Planning Act 2008 – Section 88 and the Infrastructure Planning (Examination Procedure) Rules 2010 – Deadline 6: Deferral of Environment Agency response to Deadline 7

Application by NNB Generation Company (SZC) Limited for an Order Granting Development Consent for the Sizewell C Project

Sizewell Link Road Flood Risk Assessment Addendum [REP5-045]

Plate 7.3. Maximum water levels for crossing SW6 for the 1 in 100-year +35%CC and +65%CC

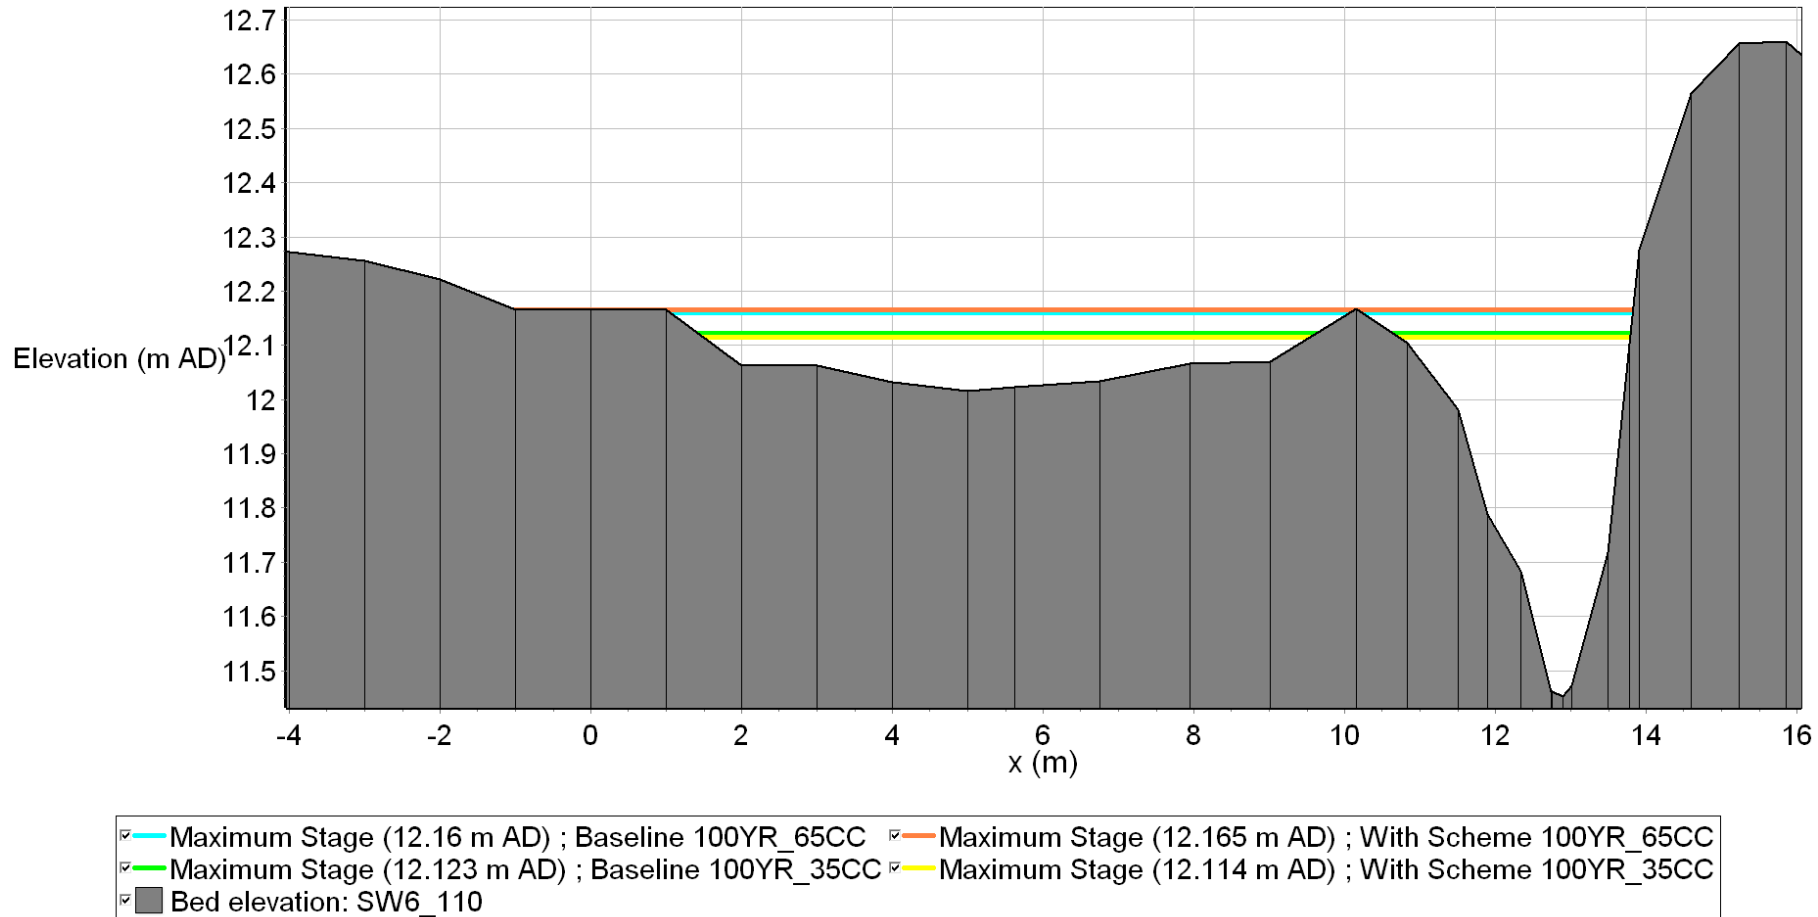
- There also remains an increase in flood risk at crossing SW6, both within and outside of the site boundary, which we do not consider to be significant. We are aware that the applicant has undertaken further analysis of this crossing that may reduce the impact of offsite flood risk, but we have yet to receive this. We are also aware that the applicant is engaging with the landowner regarding the increase in offsite flood depths.

Plate 7.4. Maximum water levels for crossing SW1 for the 1 in 100-year +35%CC - long-section

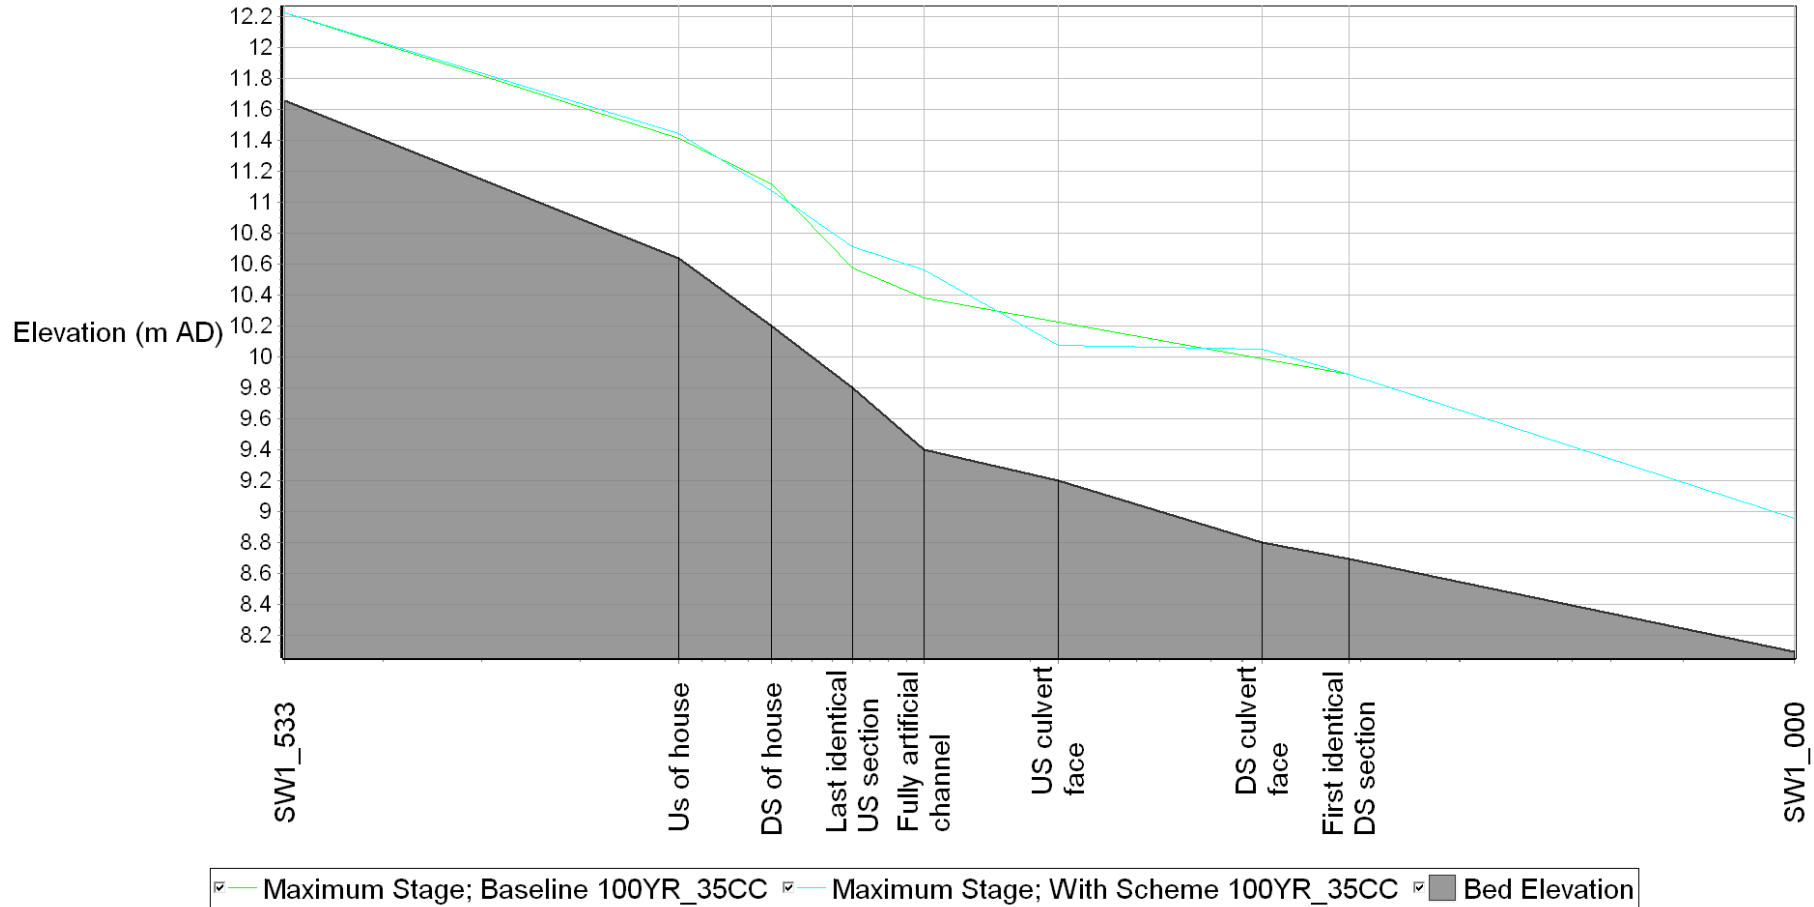
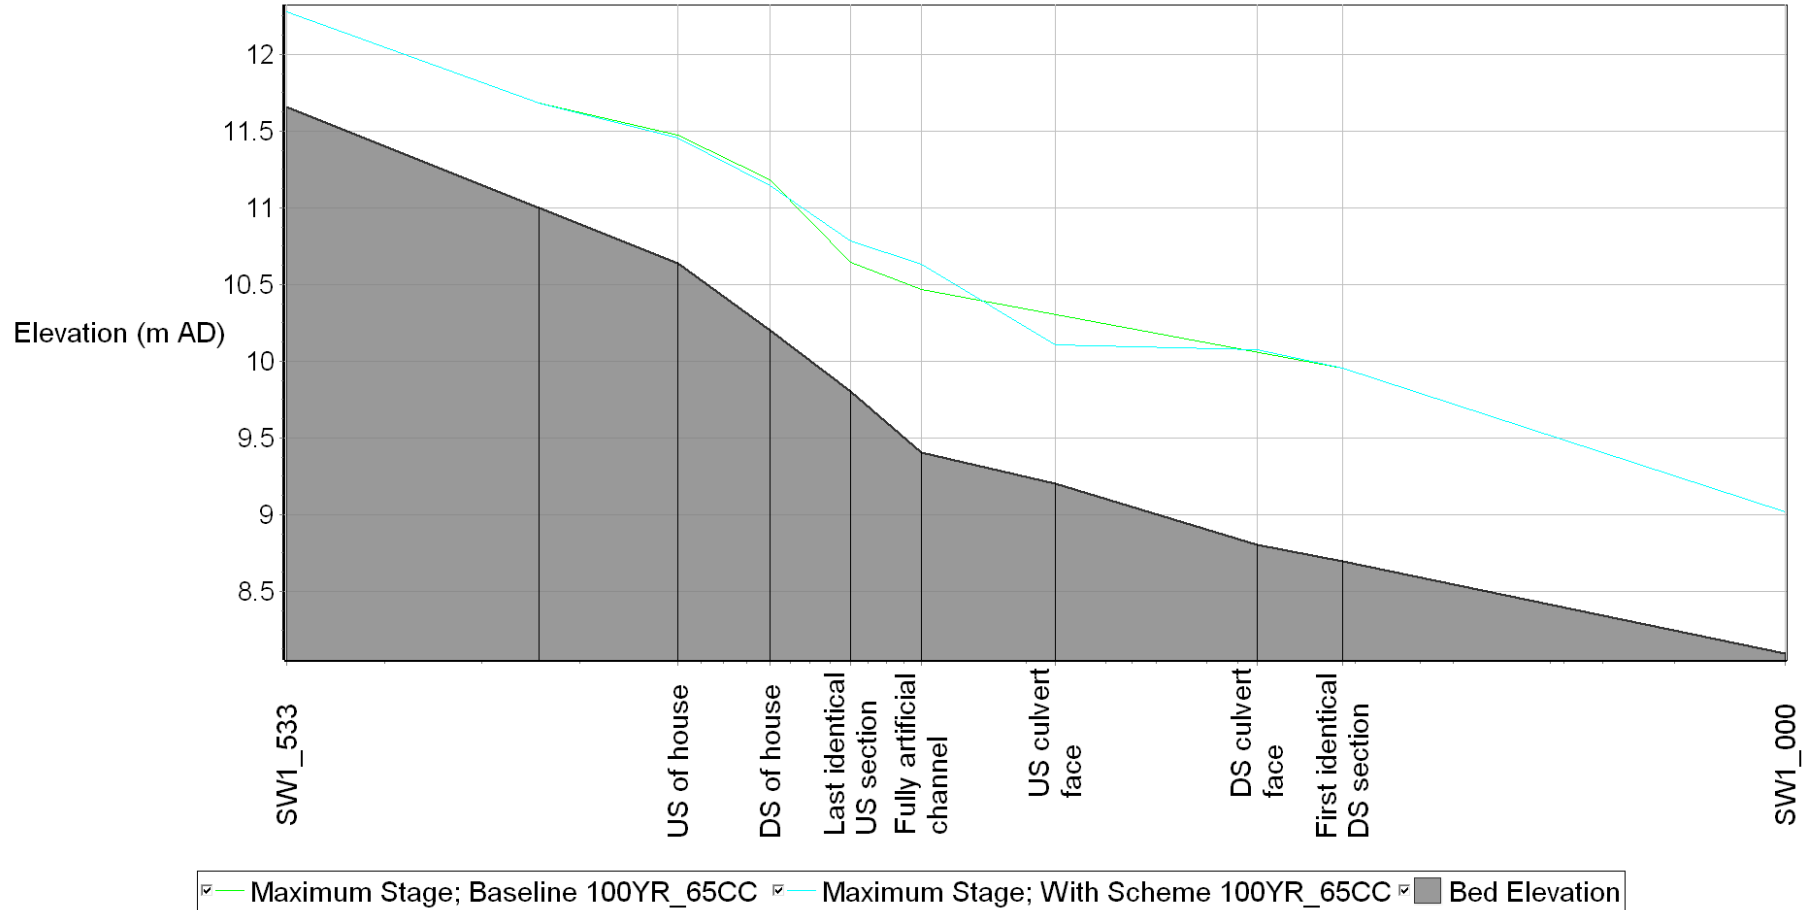
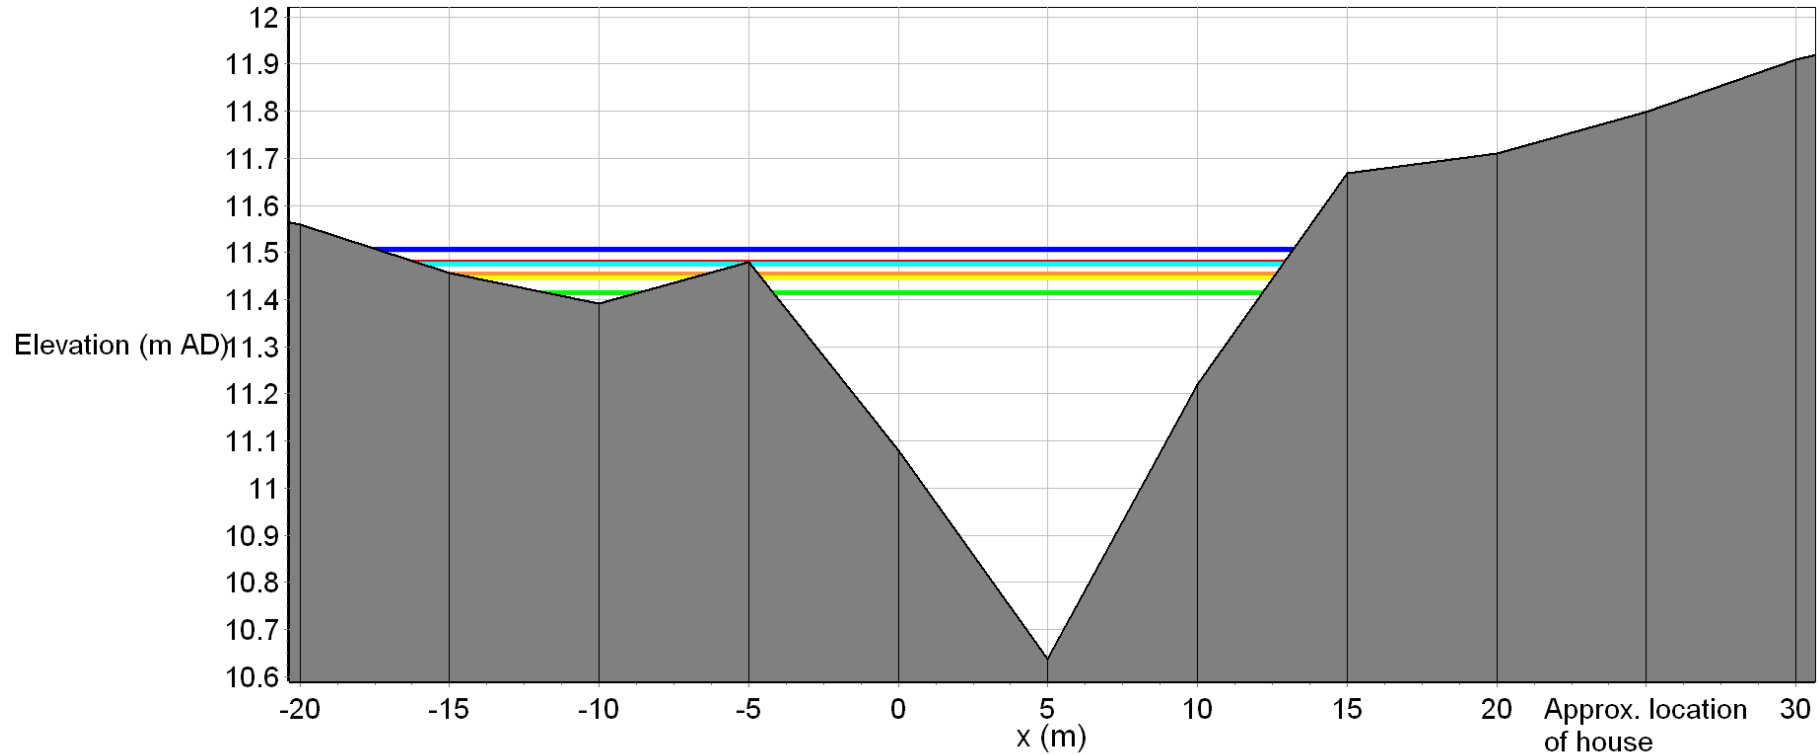
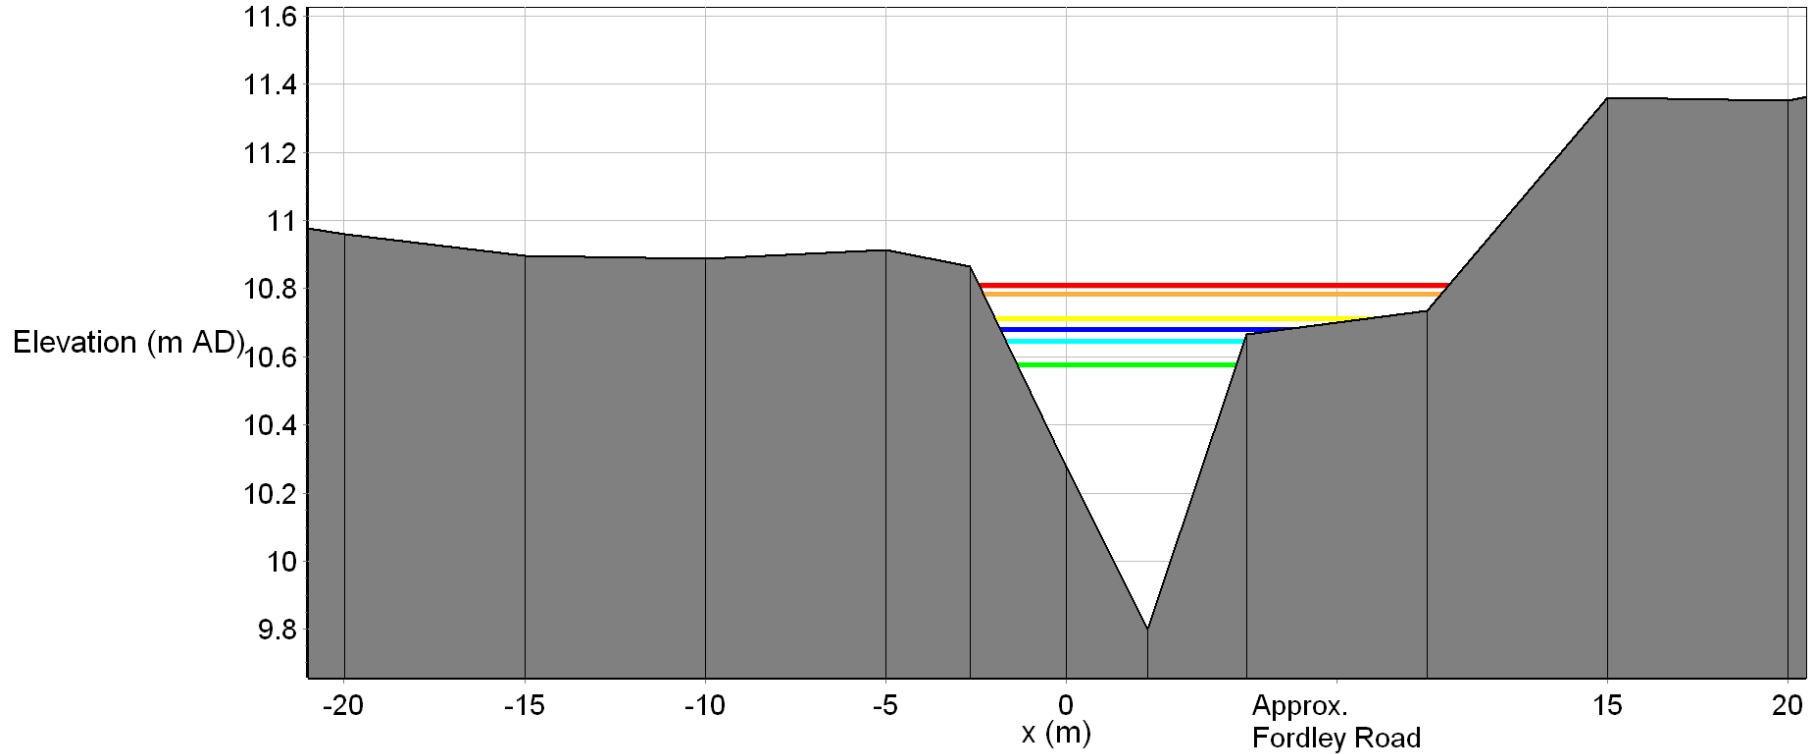
- There remains an increase in flood risk at crossings SW1 and SW3, and the applicant has clarified that this is entirely within the site boundary. We do not consider the increase in flood risk to be significant at these locations.
